Rezoning Transportation Analysis

Petition Number: Insert Zoning Petition #2021-023

General Location Identifier: Tax IDs: 22327148, 22327149, 22327150, 22327151, 22327152

Date	Description
02-25-2021	First Review (LJ)

RZ-1.0

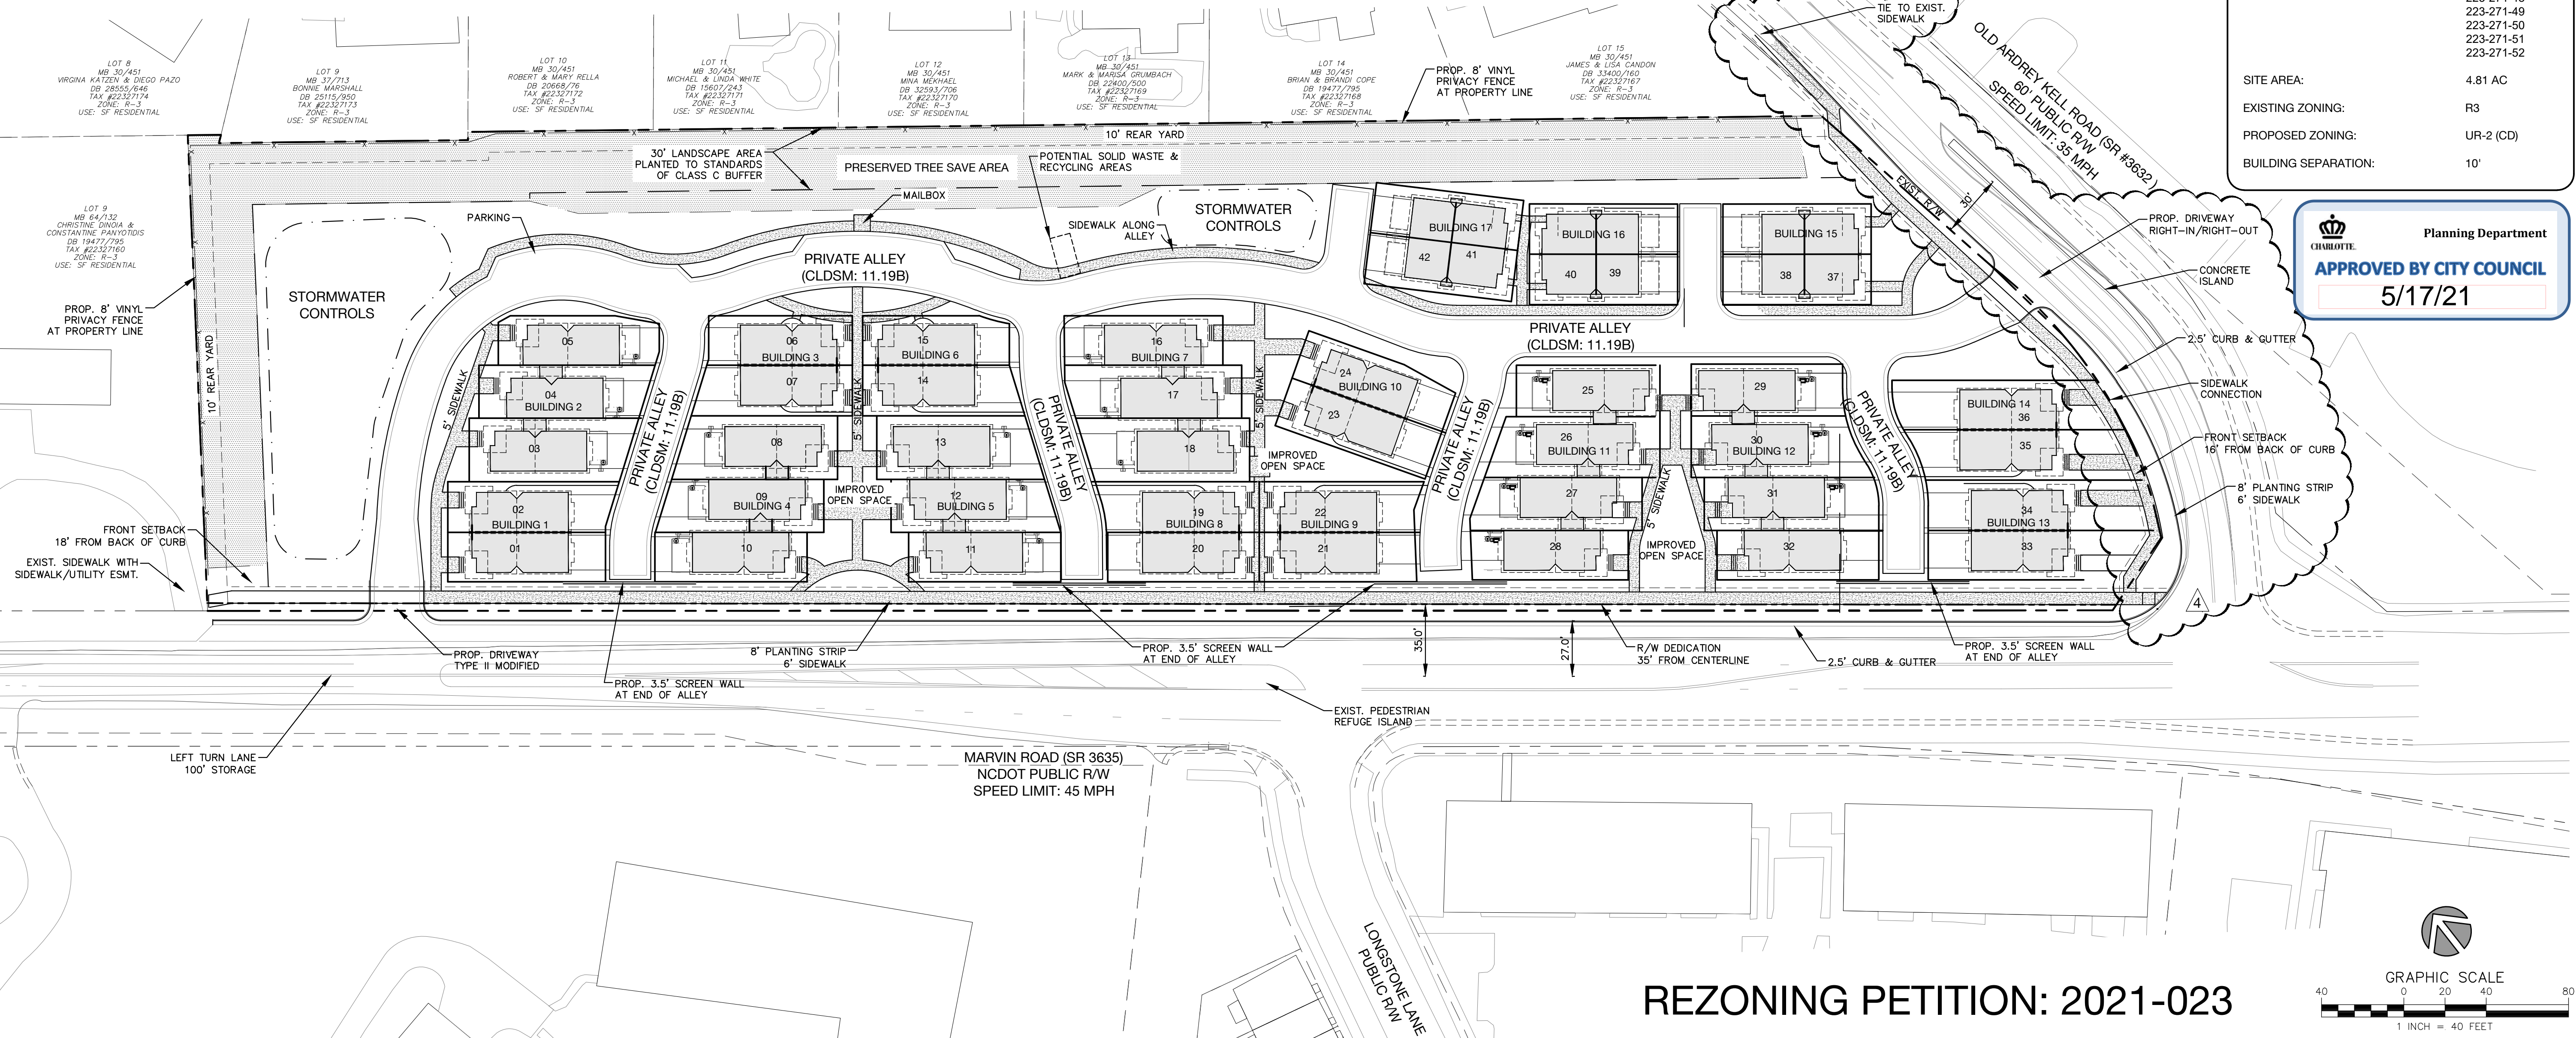
1. **Curbline:** The proposed zoning district has a setback measured from back of the existing or proposed future curbline.
 - a. **Marvin Road (NCDOT):** The future location of back of curb and gutter is 27' from the Marvin-Road centerline. Label and dimension the curb and gutter from the centerline for each road on the site plan.

Label and dimension the curb and gutter from the centerline for each road on the site plan.

- Provide a left turn lane on Marvin Road as required by NCDOT. Restripe Marvin Road, per NCDOT Roadway Standard Drawing for PAVEMENT MARKINGS Turn Lanes, 1205.05, to accommodate the left turning lane to include 100' storage.

- Petitioner will relocate the driveway access point on Marvin Road., as shown per NCDOT, and provide 100' driveway stem.

- Petitioner will relocate the driveway access point on Old Ardrey Kell Road. The access point will be a RI/RO with a porkchop median and a center median that will begin from the driveway across the street and continue to the end of the Left Turn Lane (LTL) taper to Marvin Road, as shown per NCDOT and provide 100' driveway stem.

8. Site plan and conditional note(s) revisions are needed to meet CLDSM standards as required by NCDOT. Provide a pedestrian refuge across Marvin Road, per CLDSM, 11.41, complying with ADA/PROWAG standards. The pedestrian refuge also meets the Charlotte WALKS Policy.
